Letter No. L1/ L2/13609/99

Sub: CMDA - Planning Permission - Layout of
House sites in S.No. 481/182 of Ambathur
village - Approved - Reg.

AMBATTUR MUNICIPALITY
TAMIL NADU HOUSING BOARD
LAYOUT OF HOUSE SITES IN S.No 481/1 & 481/2
OF AMBATTUR VILLAGE.
SCALE : (66 FEET TO AN INCH) 1:800.

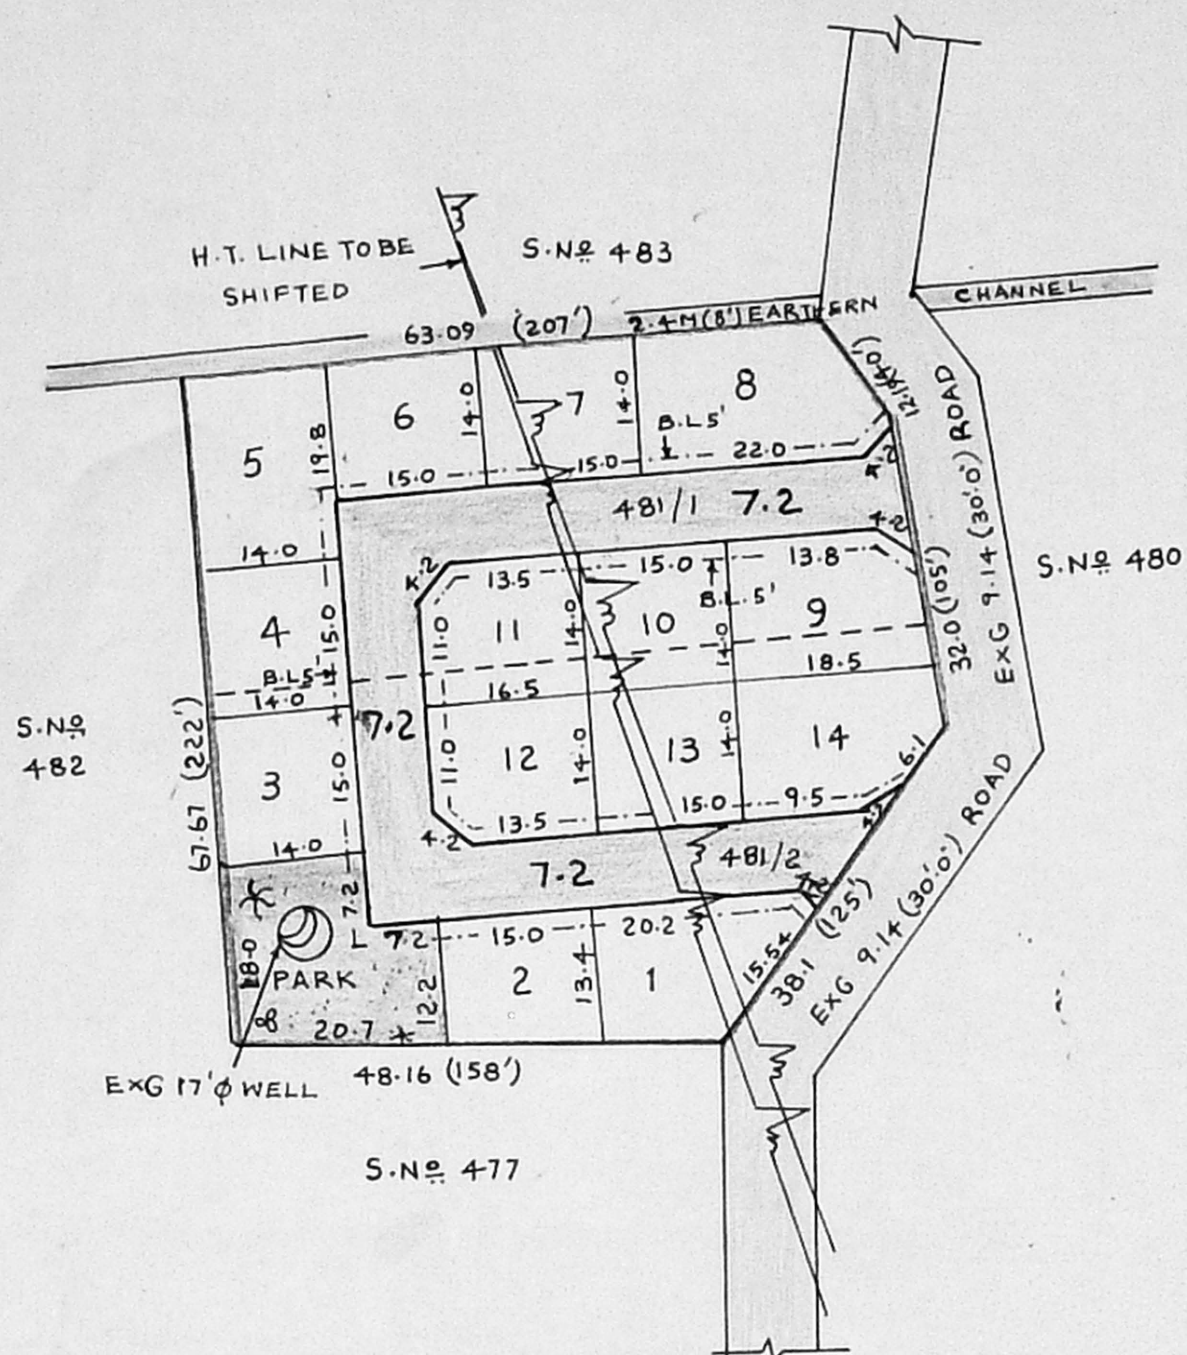
The proposal received in the reference cited for laying
out of house sites in S.No. 481/182 of Ambathur Village was examined
and layout has been revised to satisfy the Development Control
Rule requirements and approved subject to the condition that

- 1) The level of the site is to be raised to the existing road level
- ii) Power line is to be shifted before implementation of the proposal.
